11/12/2025

**Green Hill Solar Farm Development Consent Order  
LIR Landscape and Visual Matters: Comments on Applicant Response  
Document Reference: EX2/GH8.1.14**

#### **Place Services provide landscape advice on behalf of North Northamptonshire Council**

Title:
Figure 8.1.4 Site Locations and Study Area
Green Hill F & BESS

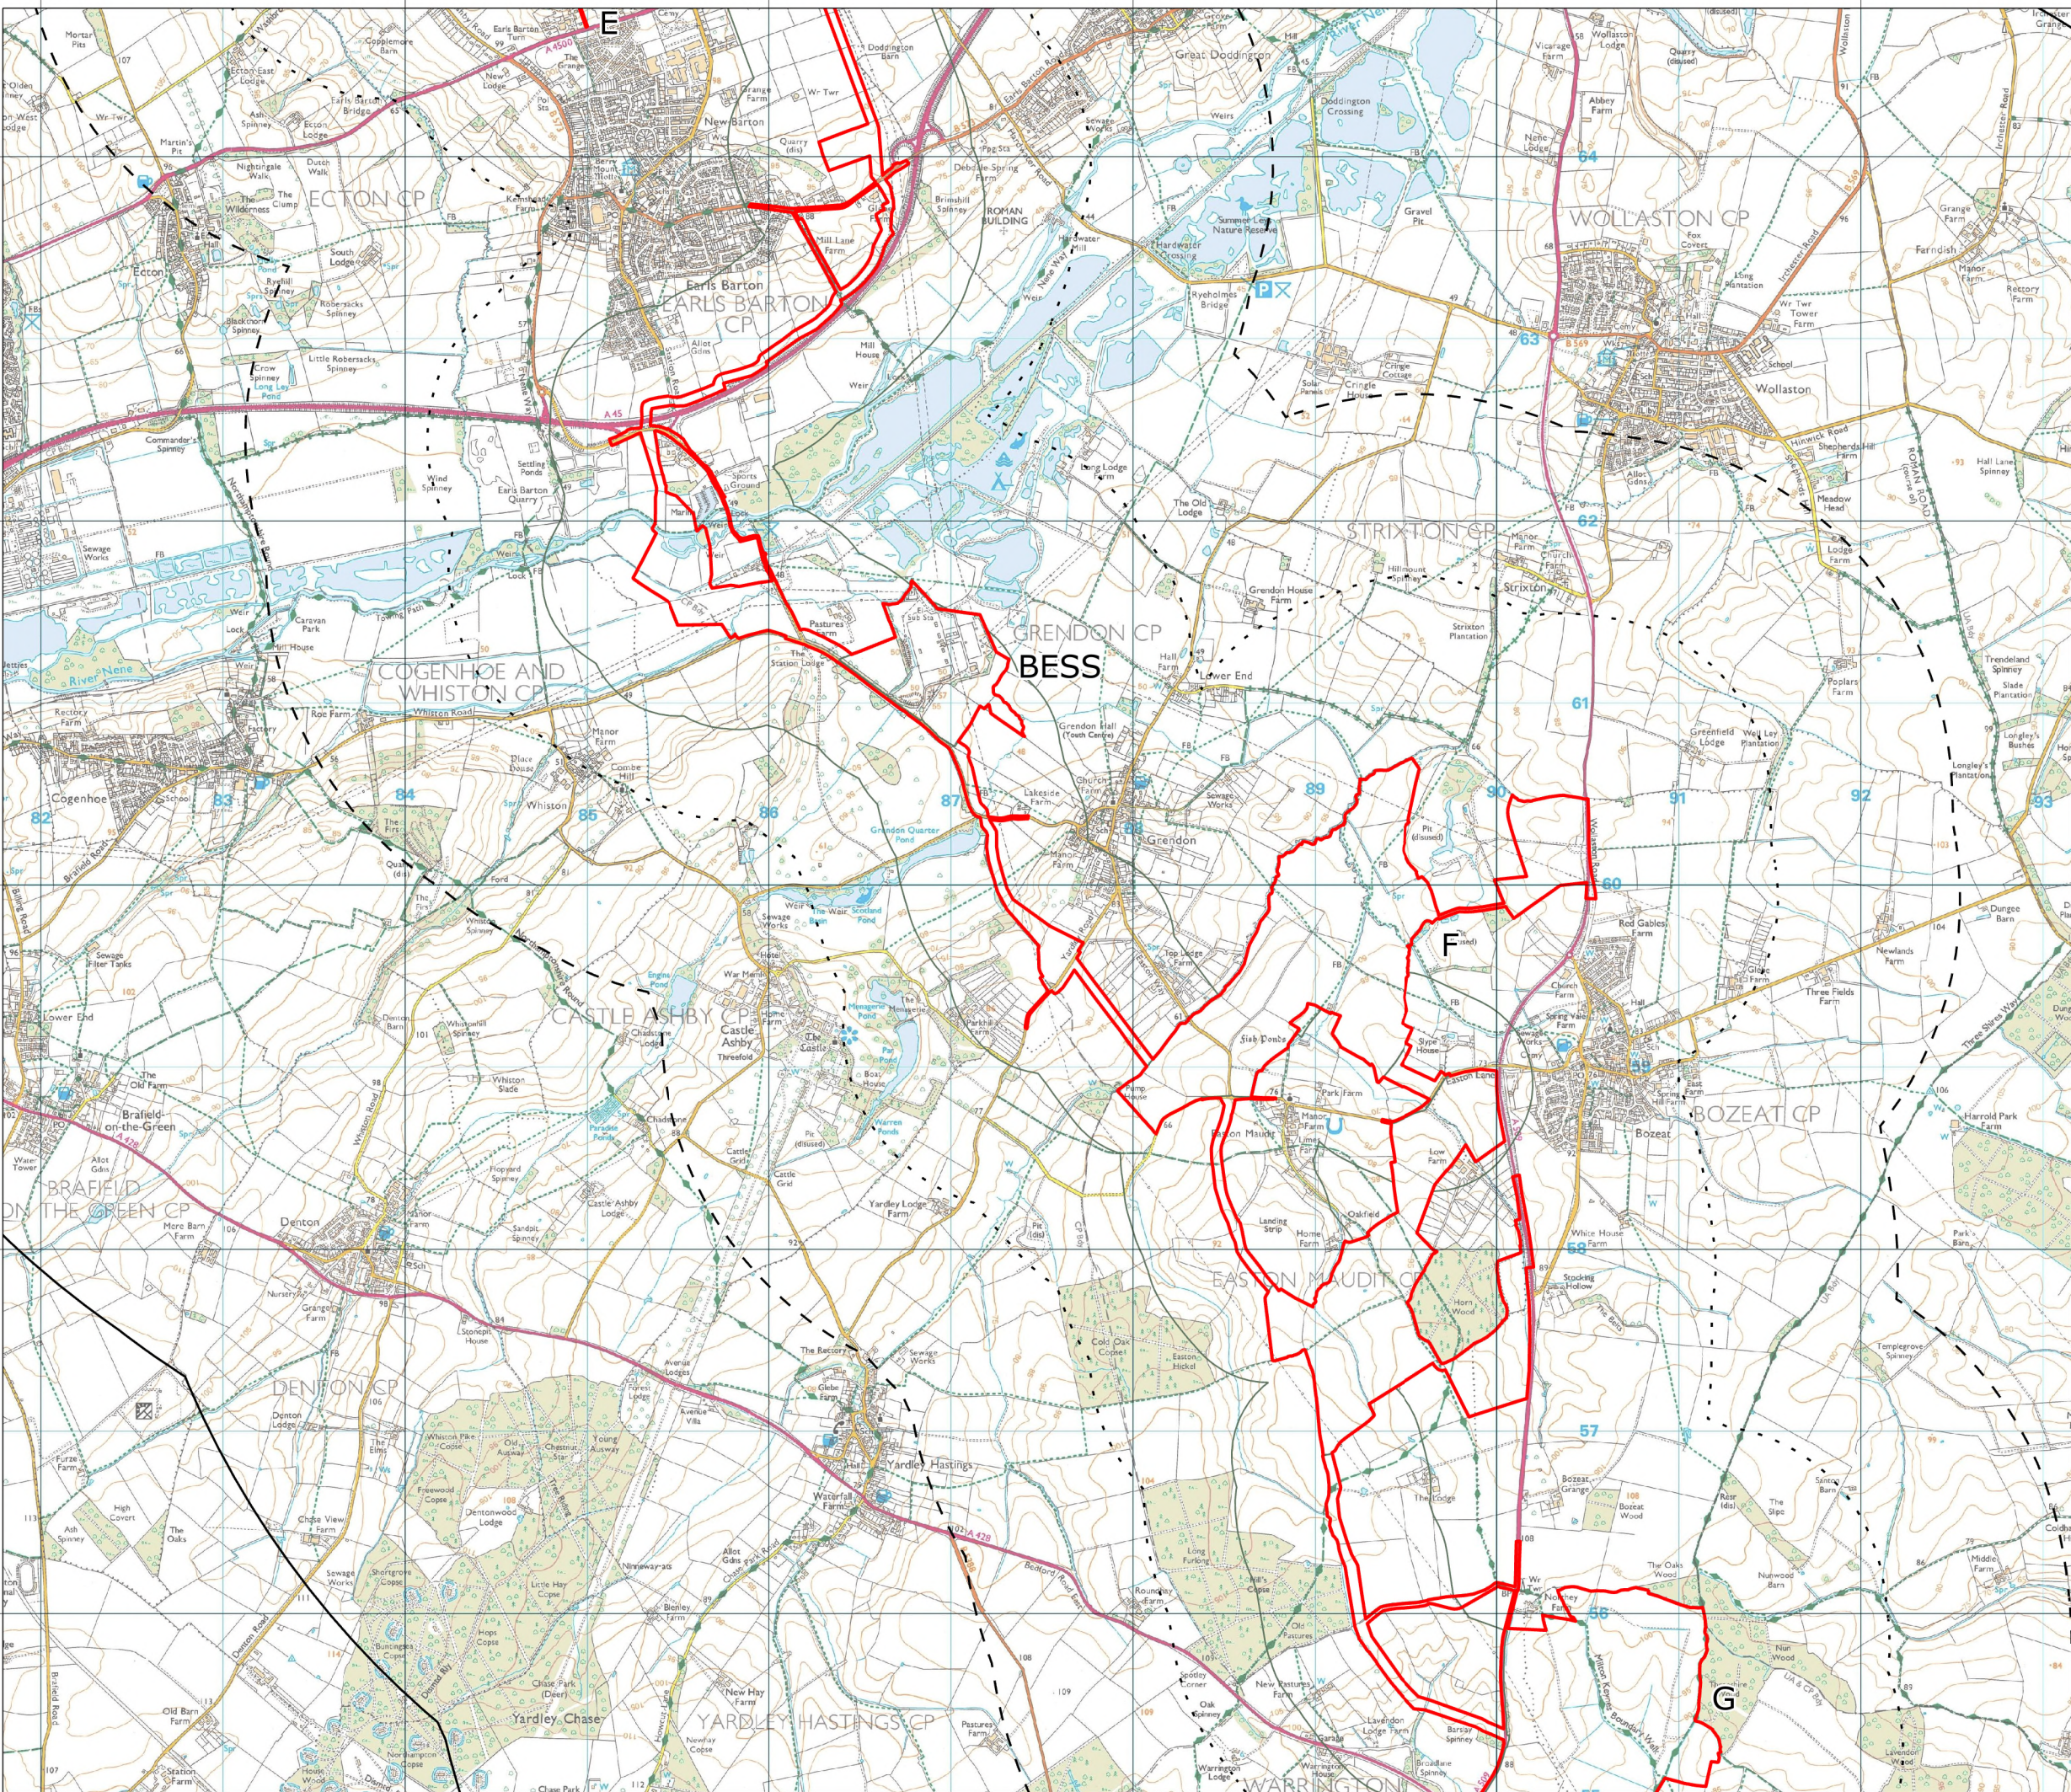
Notwithstanding this broad agreement, the Council maintains that certain sites exhibit characteristics that justify a higher degree of susceptibility than reflected in the ES. In particular, Site F displays more noticeable topographic variation than other parts of the scheme, creating a landscape that is more open to perceptual changes and appreciation of the countryside. Even where direct visibility is intermittent or filtered, the underlying landform means that solar development would sit within a more visually sensitive setting compared with flatter or more enclosed sites.
